March 22, 2024

RE: SP-24-00001 4G Farms – Notice of Application

WALKER DRIVE SHORT PLAT
 PART OF SECTION 32,
 T. 18 N., R. 19 E., W.M.
 KITTITAS COUNTY, WASHINGTON

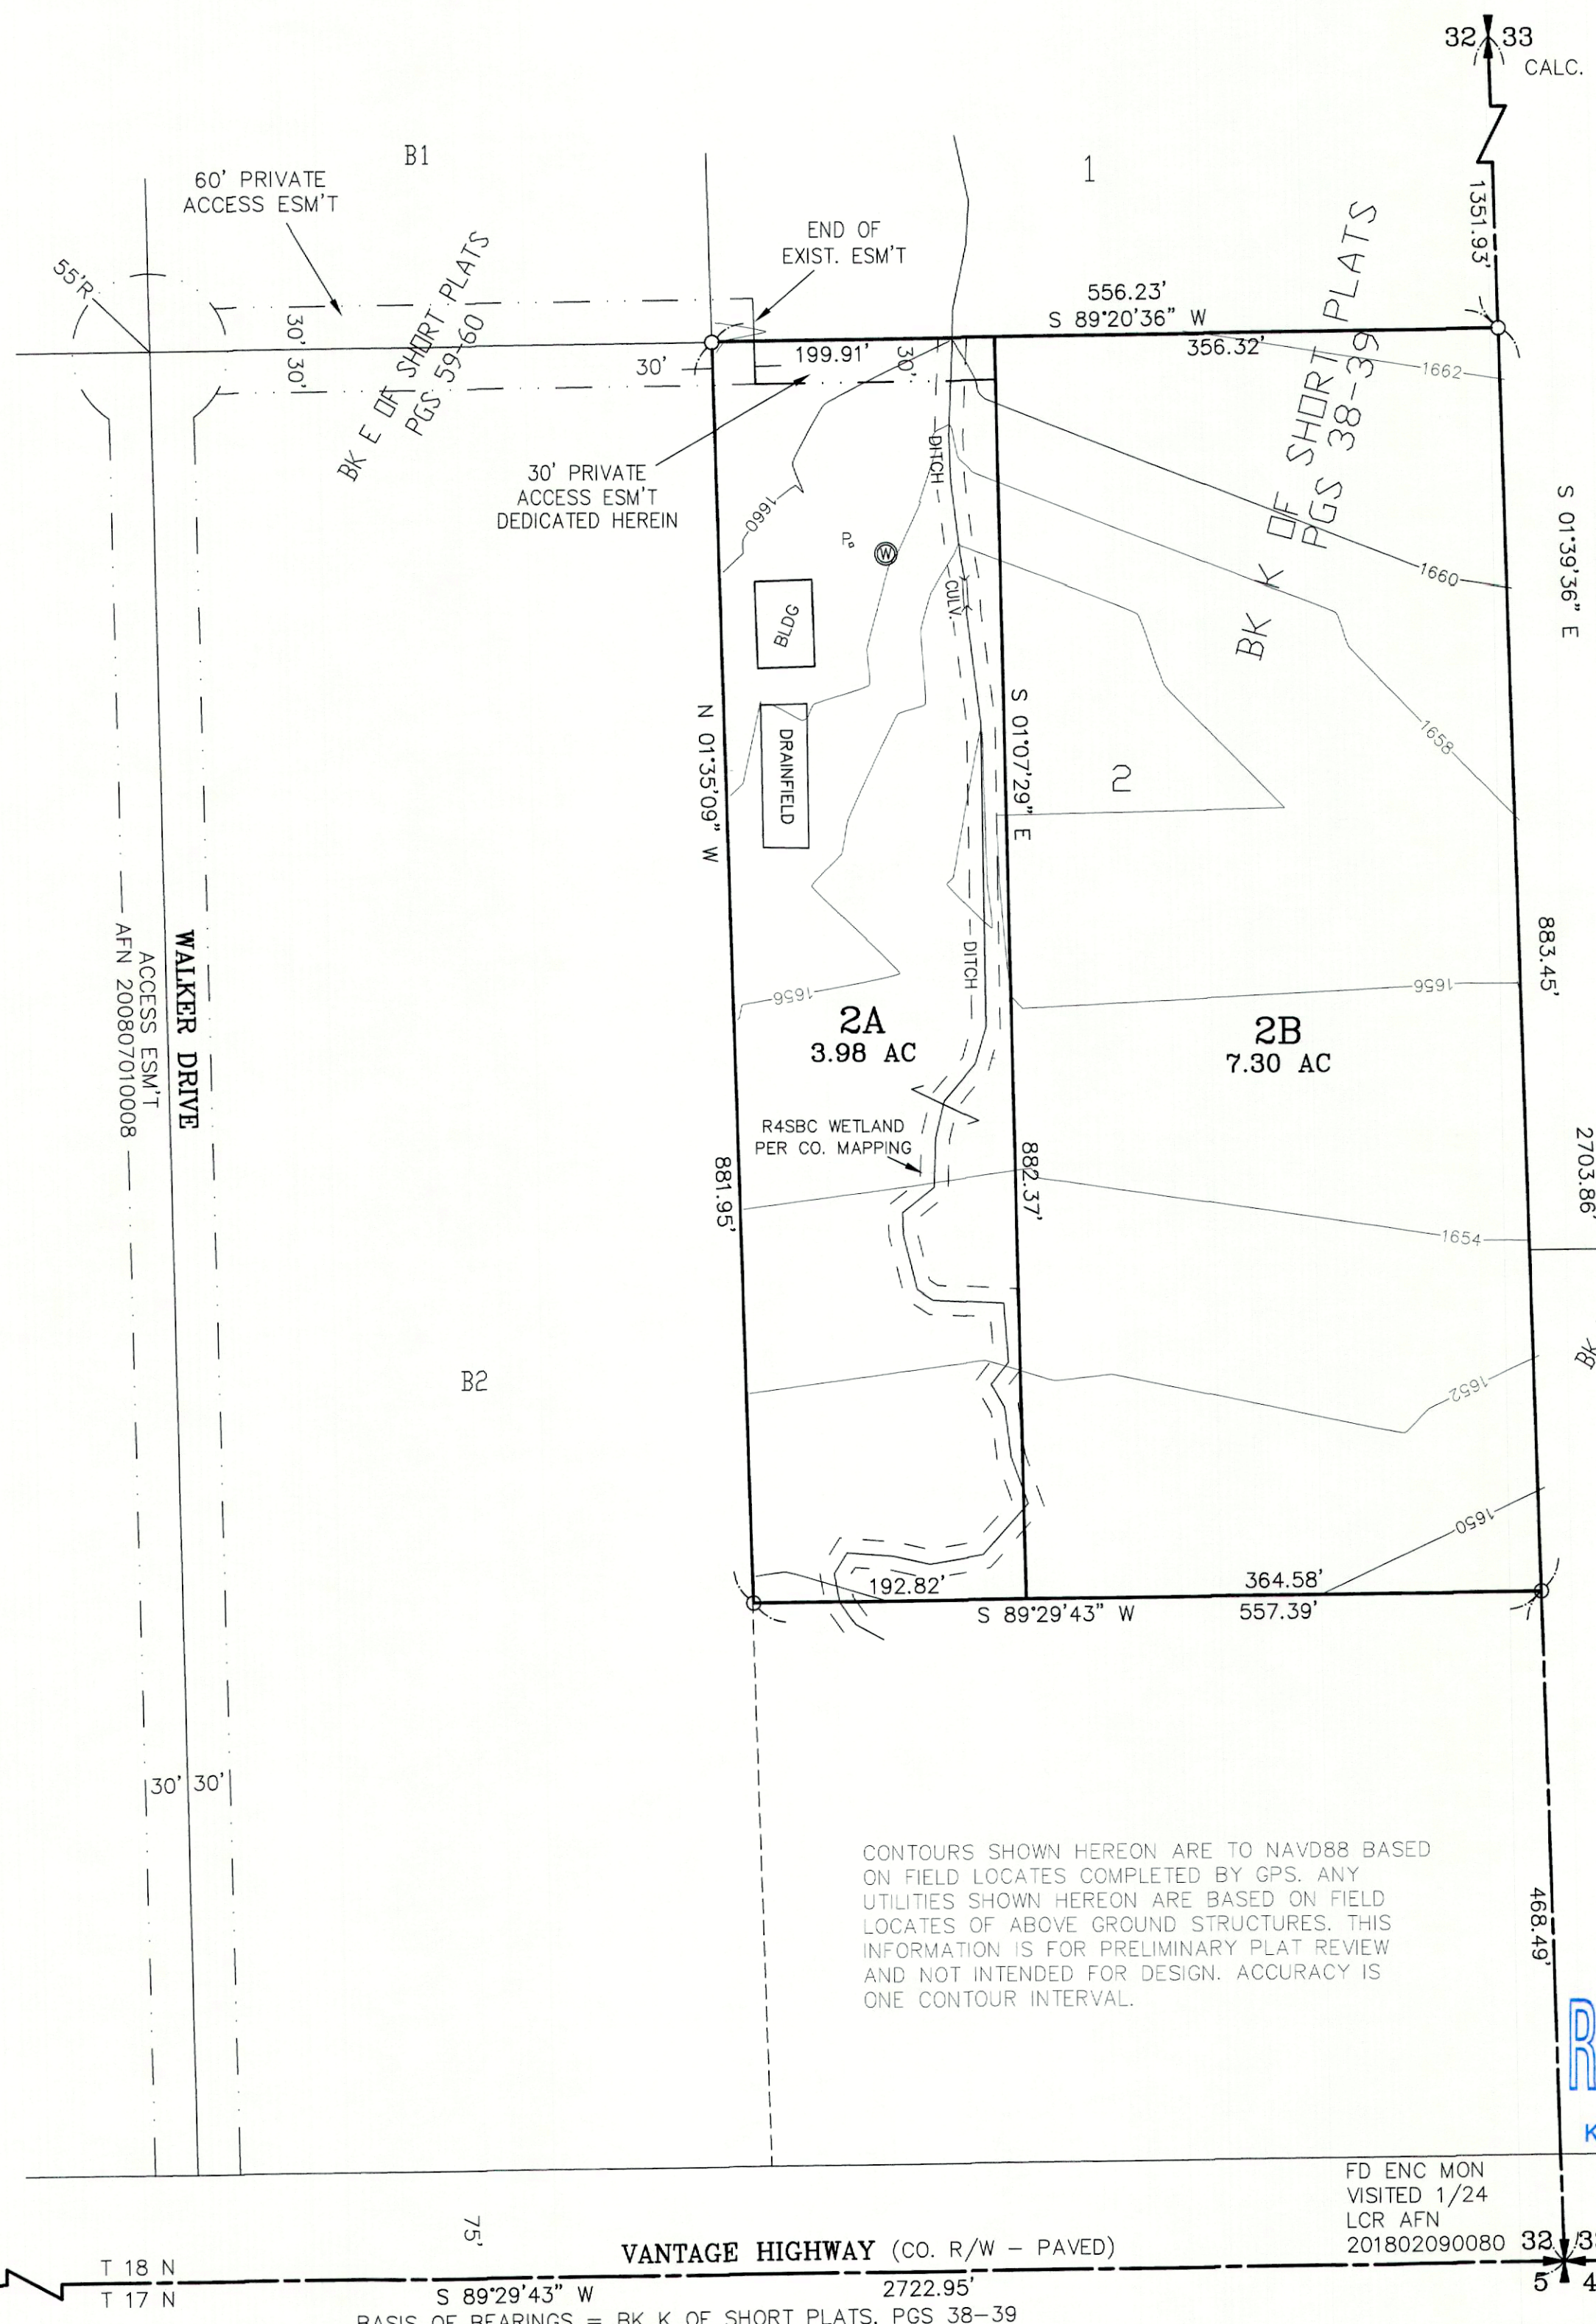
The following comments are the Environmental Public Health comments on the SP-24-00001 4G Farms Notice of Application. The proposed lot 2B is required to have a well drilled and a soil log performed by the Kittitas County Public Health Department before final plat signature can be obtained.
